**Office of
Environment
& Heritage**

Your reference: SSD 6324
Our reference: DOC15/19578
Contact: Jennifer Charlton
02 8837 6311

ATTACHMENT 1: OEH comments regarding State Significant Development Application for Bringelly Road Business Hub, Leppington (SSD 6324)

Figure 3: Landuse, vegetation community and fauna habitats mapped on the subject site. Dams are labelled 1–5.

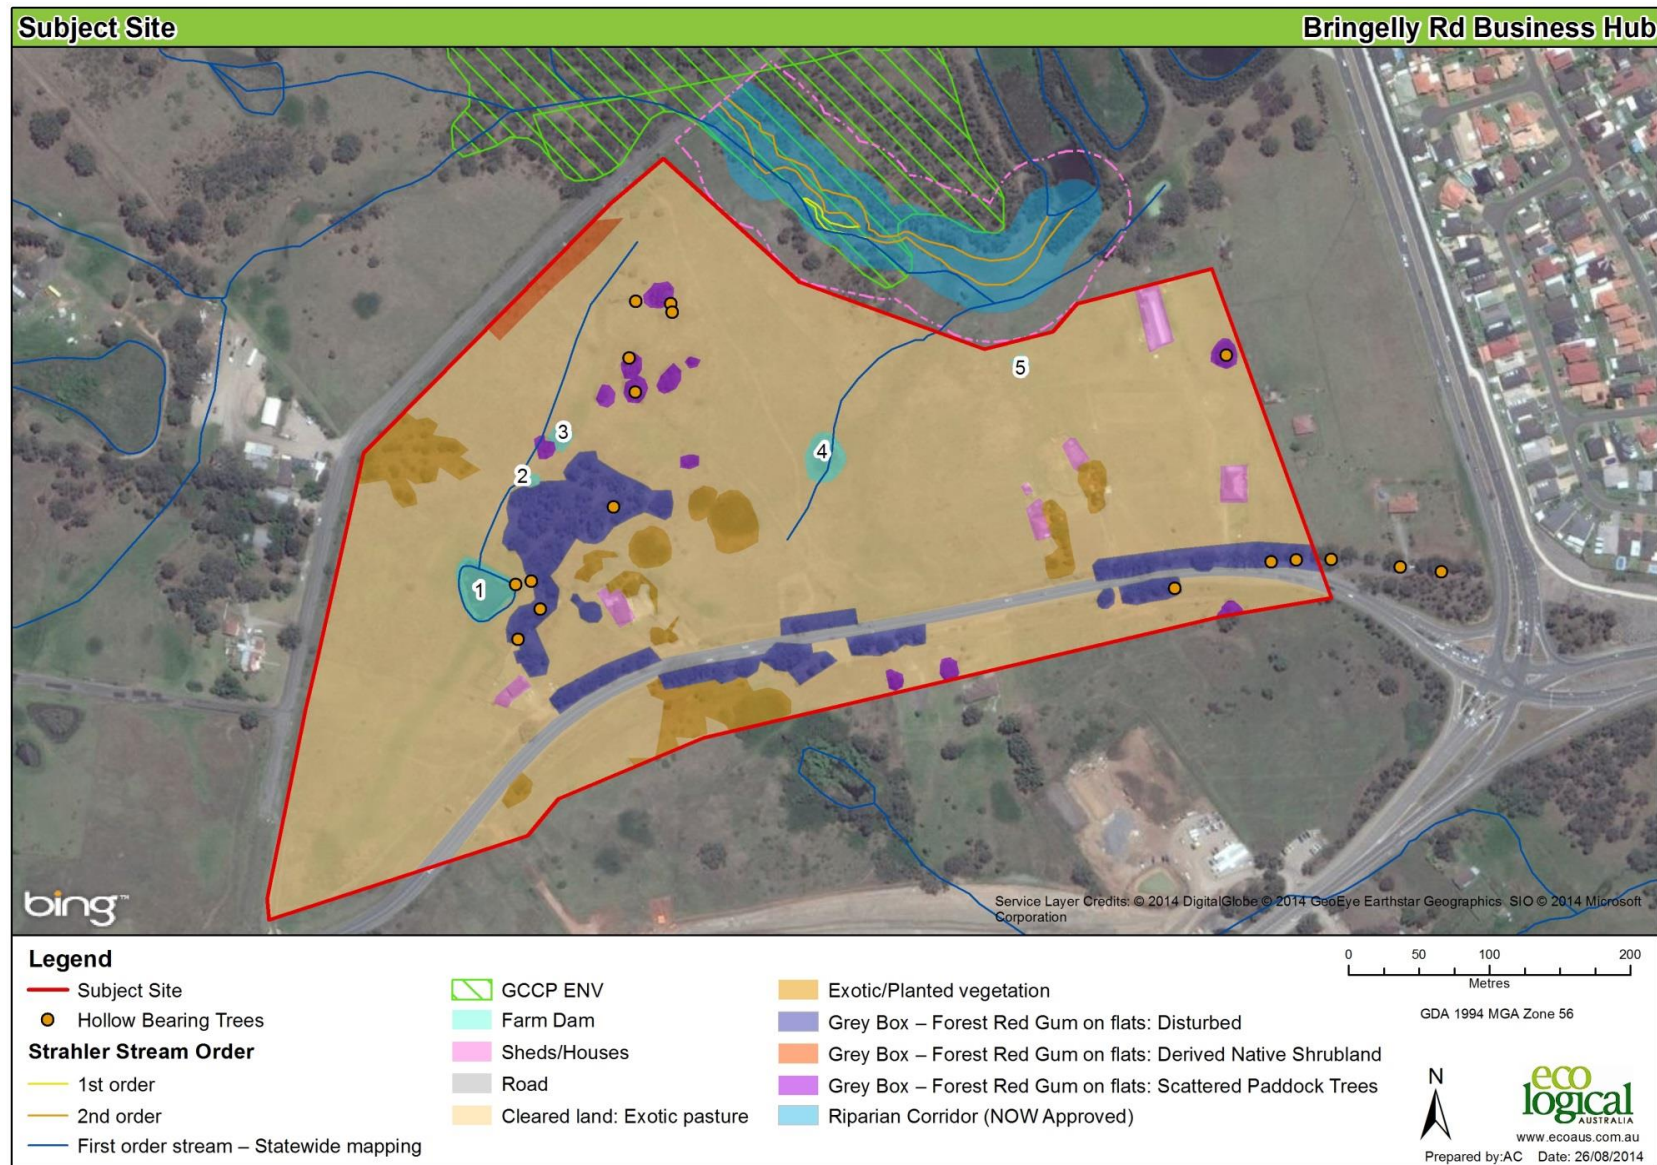
- Neither the EIS nor Flora and Fauna Assessment specifically address the DGR relating to assessment of the impacts of the proposal in regard to the Biodiversity Certification Order for the Sydney Region Growth Centres. However, Figure 3 of the Flora and Fauna Assessment identifies existing native vegetation (ENV) as defined by the Order; OEH notes that no ENV would be removed by the proposed project.
